Current Zoning: N1-A (neighborhood 1-A)
Proposed Zoning: N2-A(CD) (neighborhood 2-A, conditional)

Approximately 12.11 acres located on the south side of Sunset Road, east of Oakdale Road.

The petition proposes the development of up to 110 multi-family attached dwellings and 4 duplex lots. The property is currently the site of 2 single-family dwellings.

Sunset Road Partners, LLC

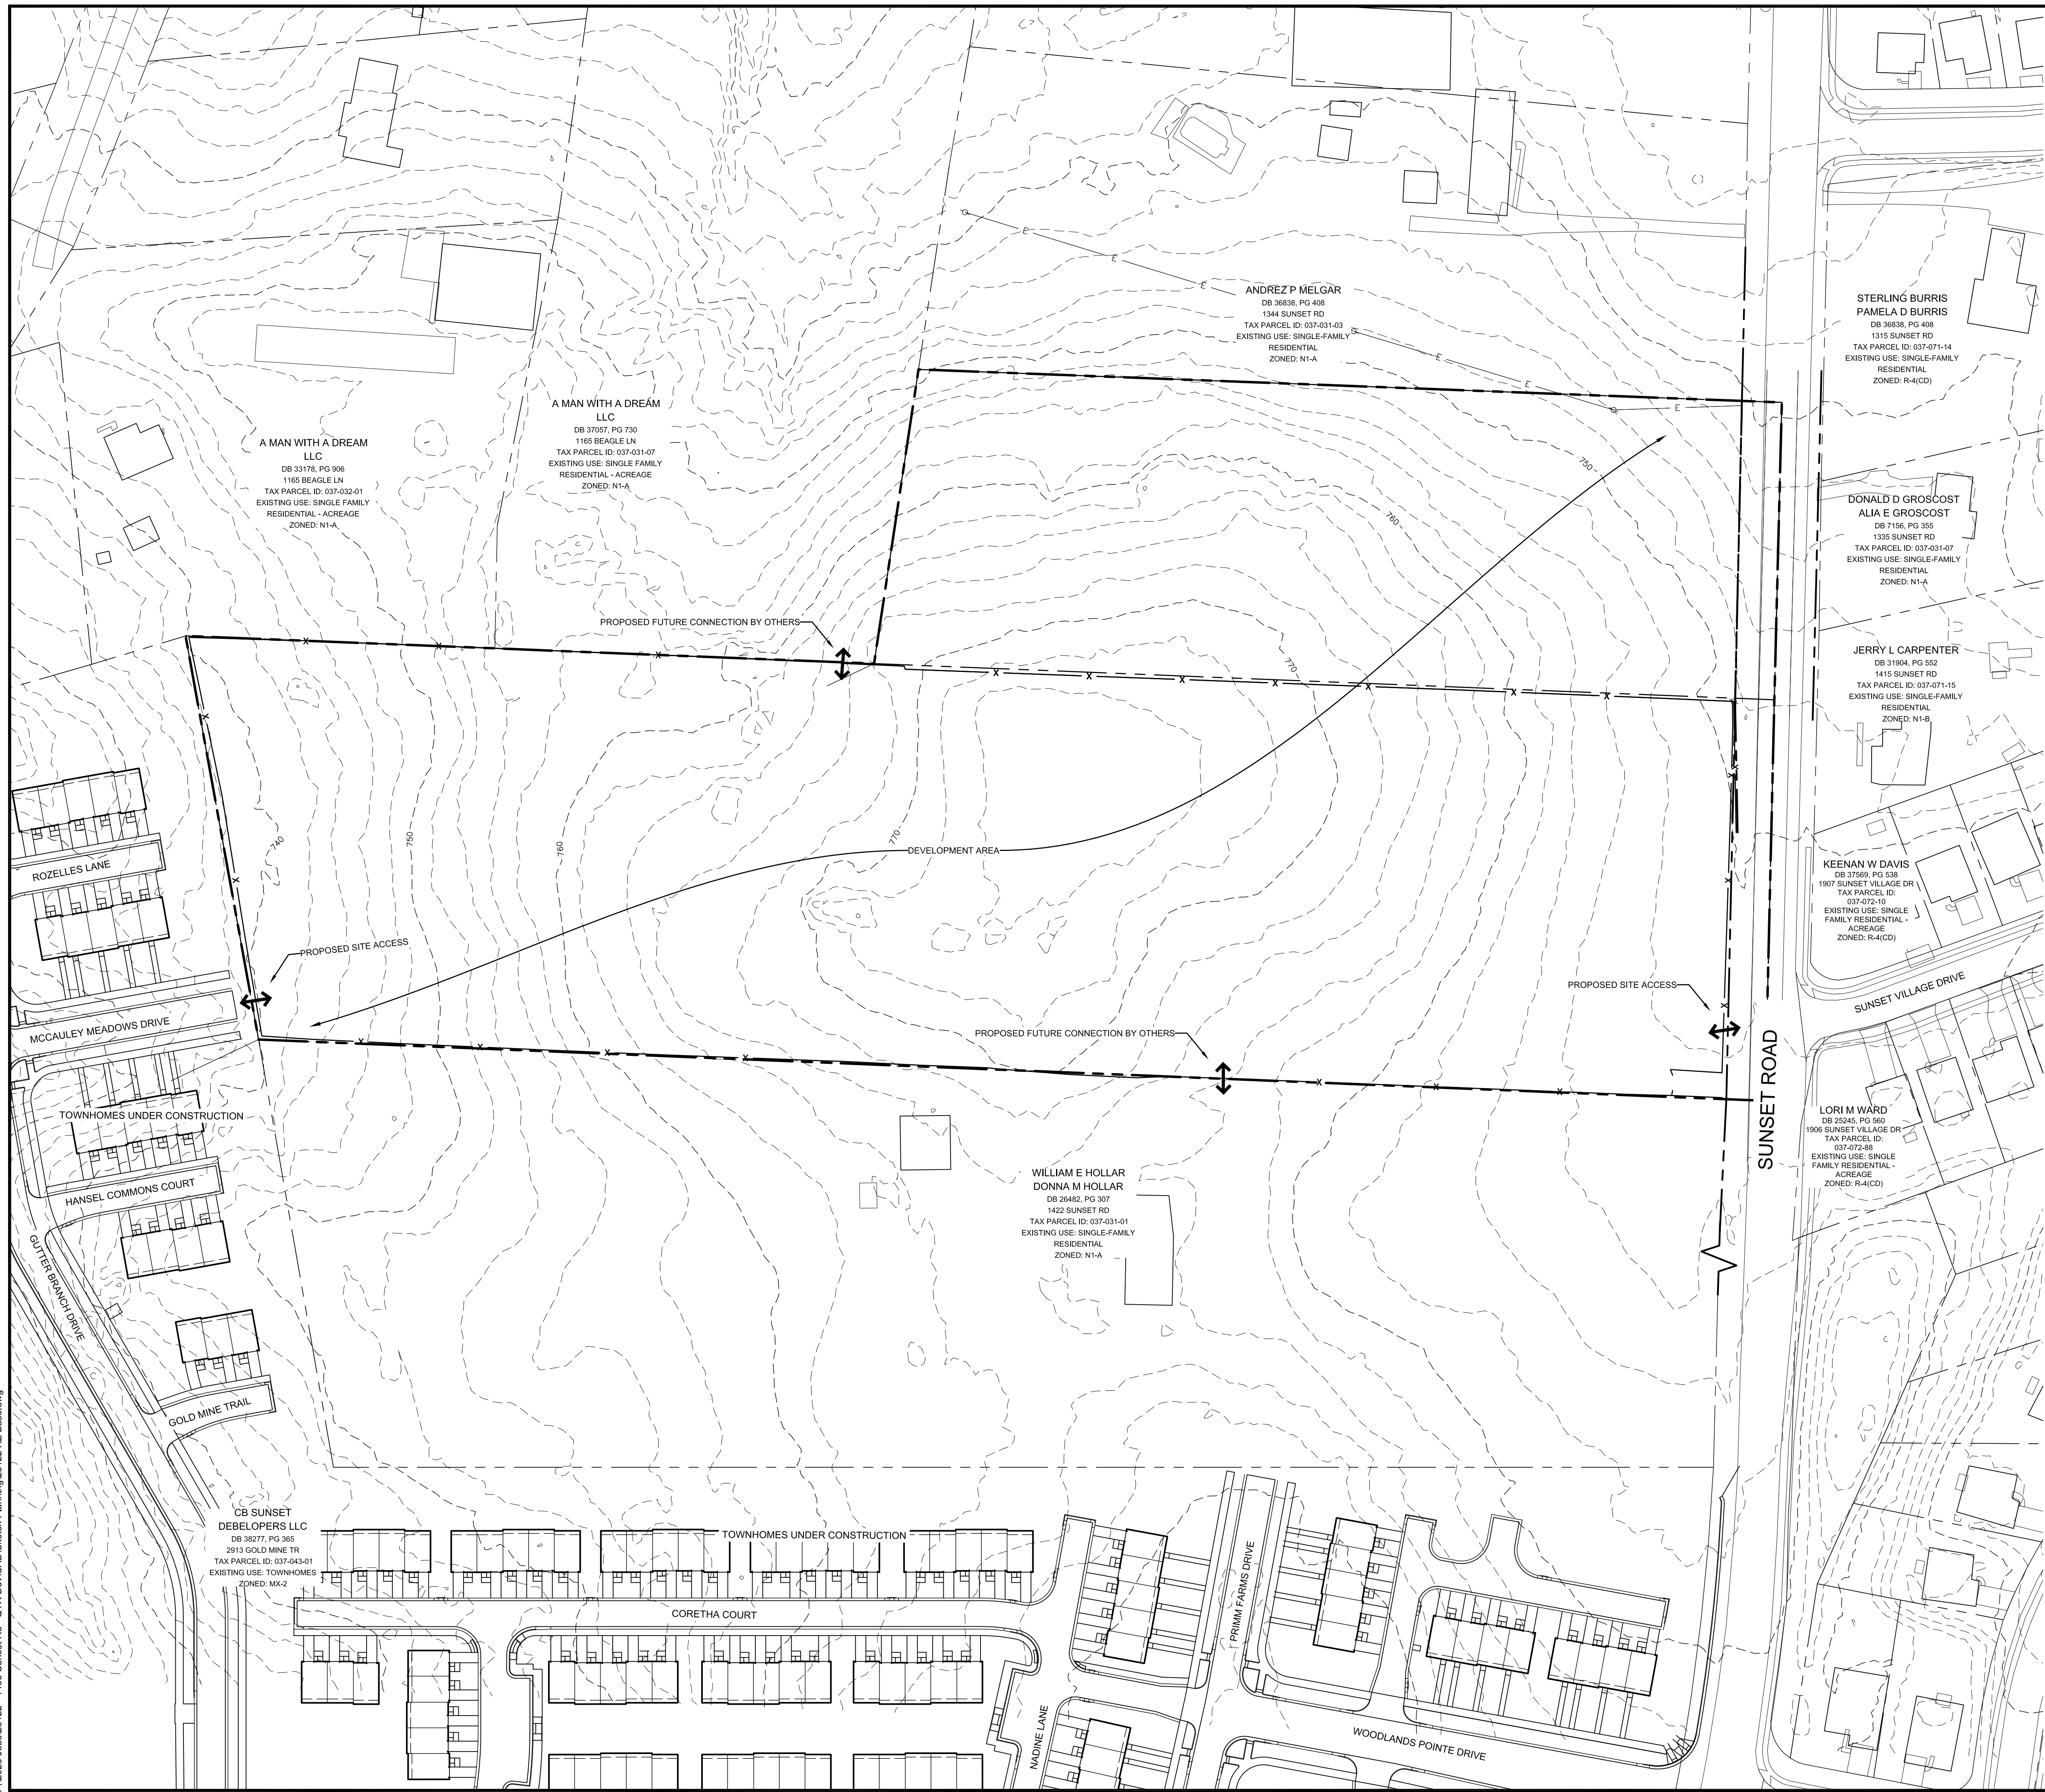
1. Revise site plan and conditional note(s) to commit to creating cross-access with the Northern Parcel fronting Sunset Road per Article 31.2 in the UDO.

2. Stormwater: Add note regarding mitigation of impaired/degraded stream.
3. Stormwater: Add note regarding analysis of adequacy of the existing storm water conveyance to the nearest public right-of-way.
4. Urban Forestry: A tree survey shall be required for all conditional zoning map amendments.
